SITE MAP

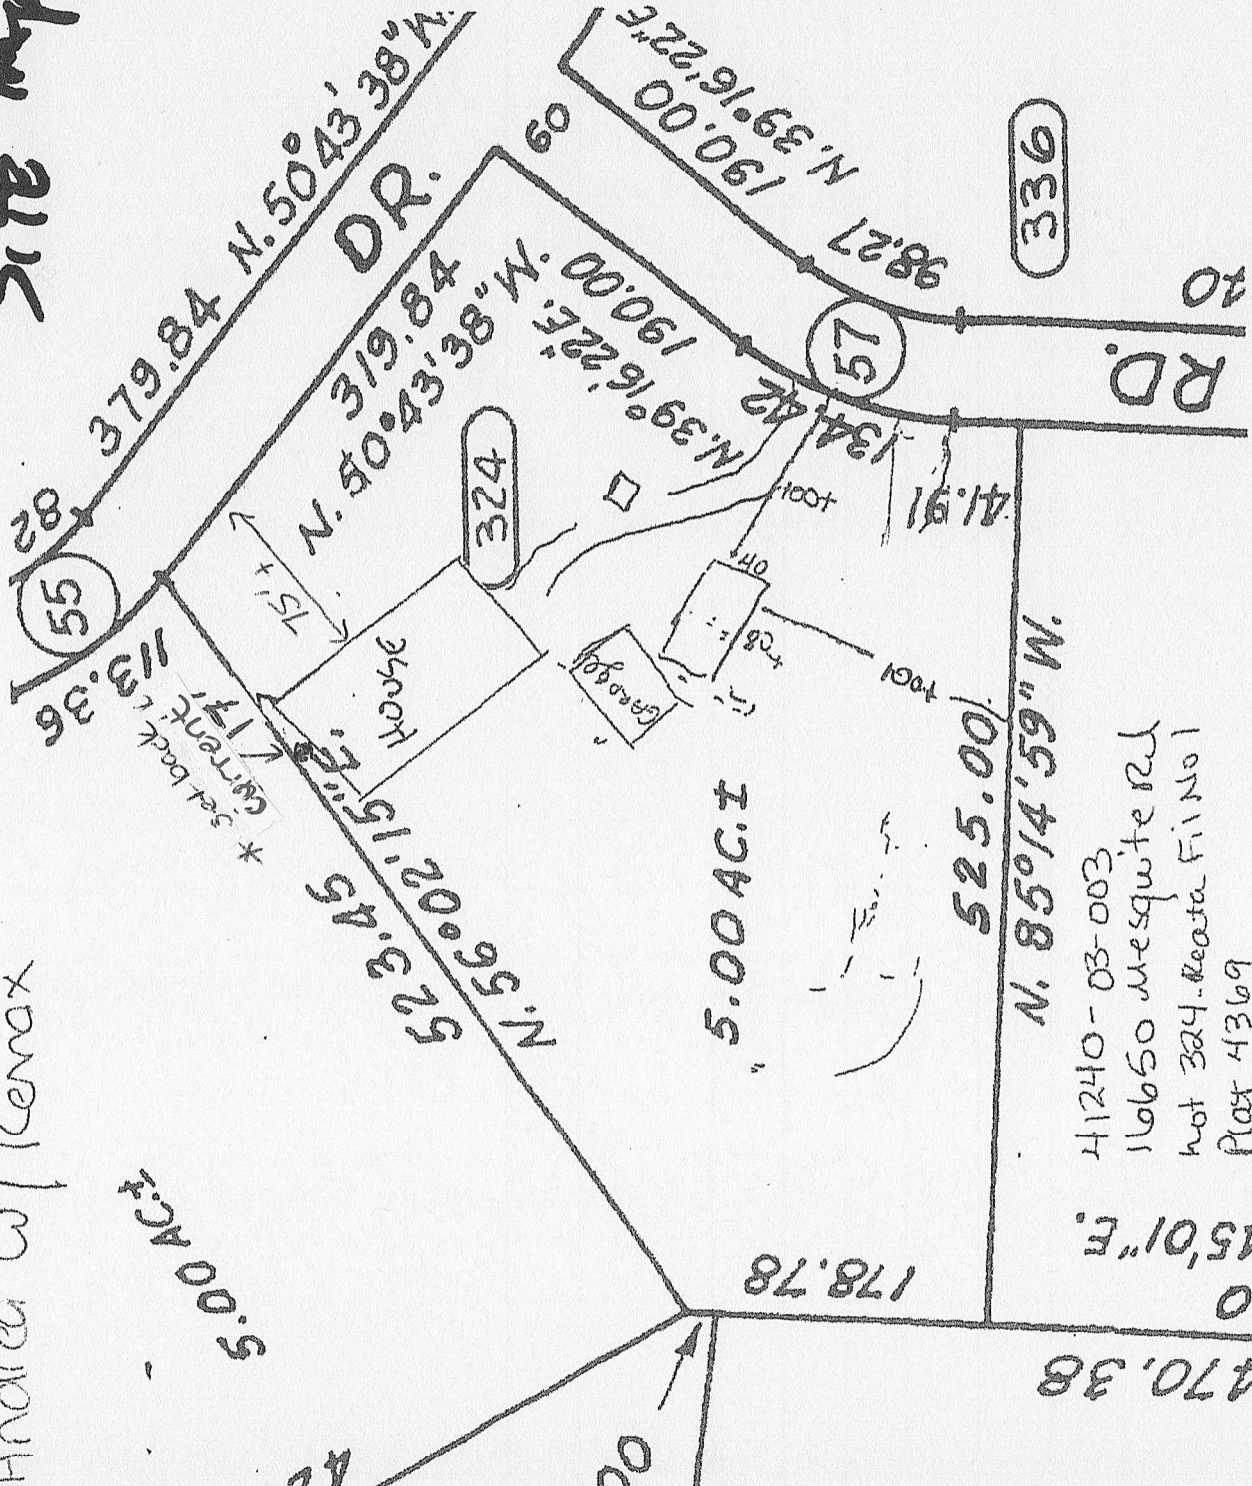
You need to show the exact setbacks from property lines, especially the one that is in question. Add a north arrow on the site plan. Add a scale or mark it as "not to scale". Include dimensions and setbacks of all buildings.
